<b>Project name</b>	A46 Newark Bypass
<b>File reference</b>	TR010065
<b>Status</b>	Final
<b>Author</b>	The Planning Inspectorate
<b>Date</b>	21 July 2023
<b>Meeting with</b>	National Highways
<b>Venue</b>	Microsoft Teams
<b>Meeting objectives</b>	Project Update Meeting
<b>Circulation</b>	All attendees

### A46 Newark Bypass – TR010065

#### Section 51 advice regarding draft application documents submitted by National Highways

Figure 2-1: Scheme location and location of the principal elements

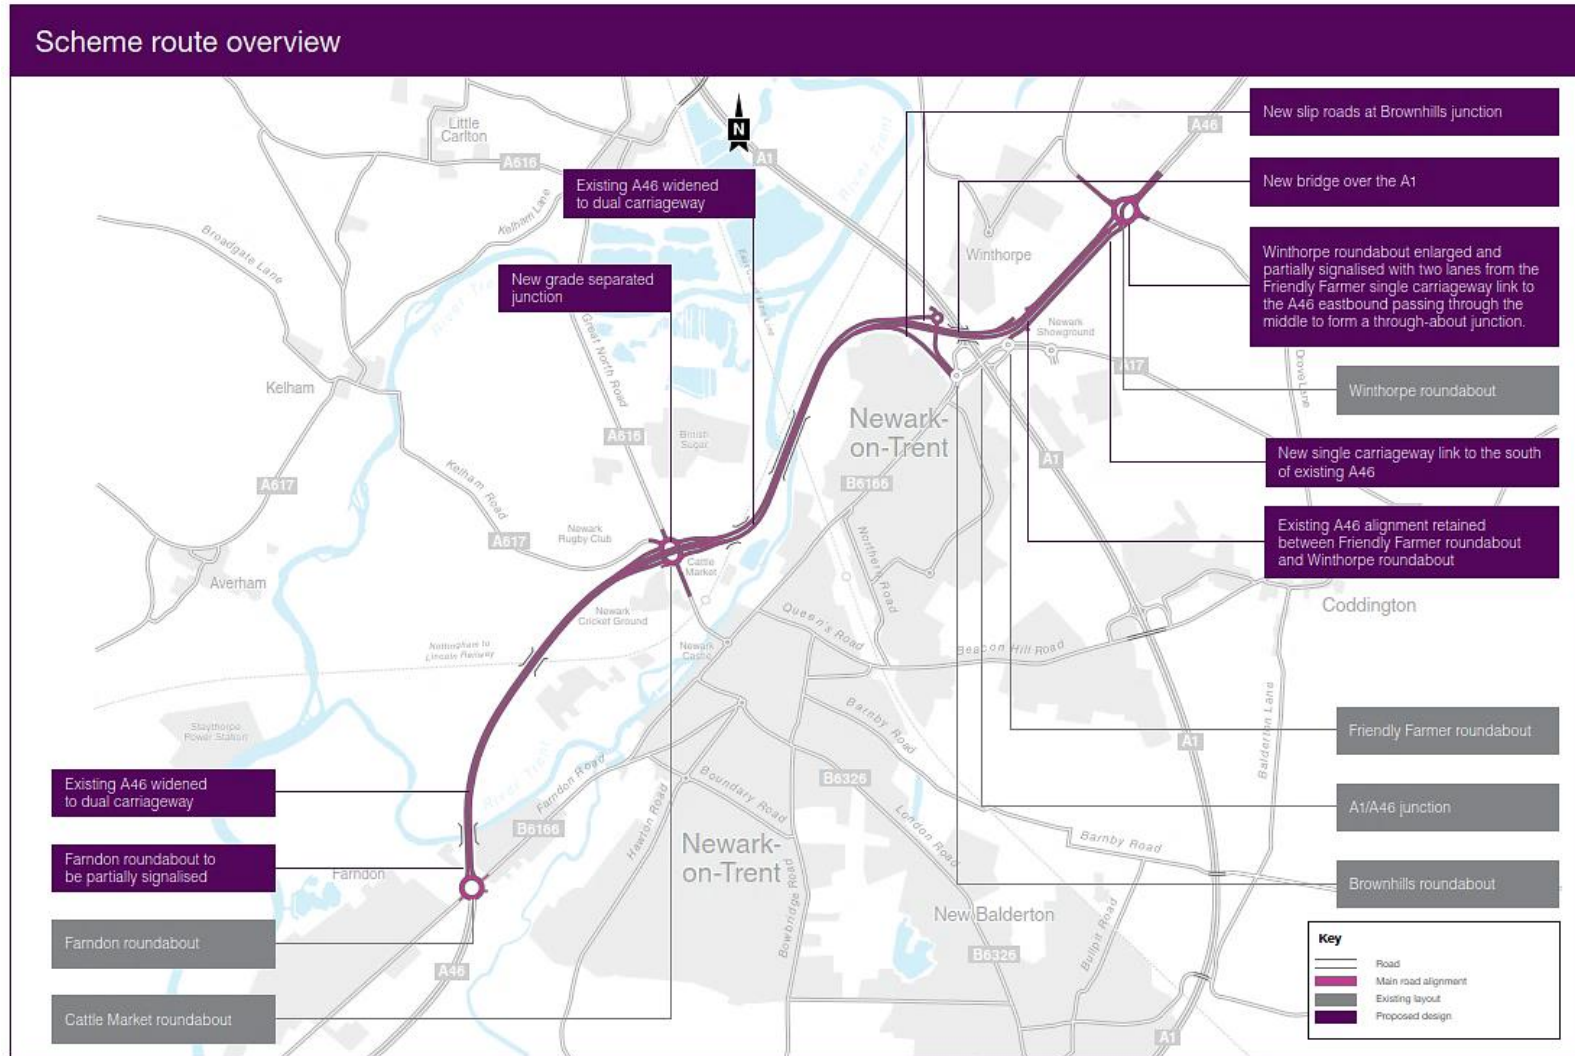
3.	General	The contents page should include a list and links to the Tables and Figures that have been embedded into the text.
4.	General	Figure 2.1 depicting the location of the Proposed Developed is low resolution and unreadable in places. Figures that are embedded in the text of the ES should be clear and easy to understand.
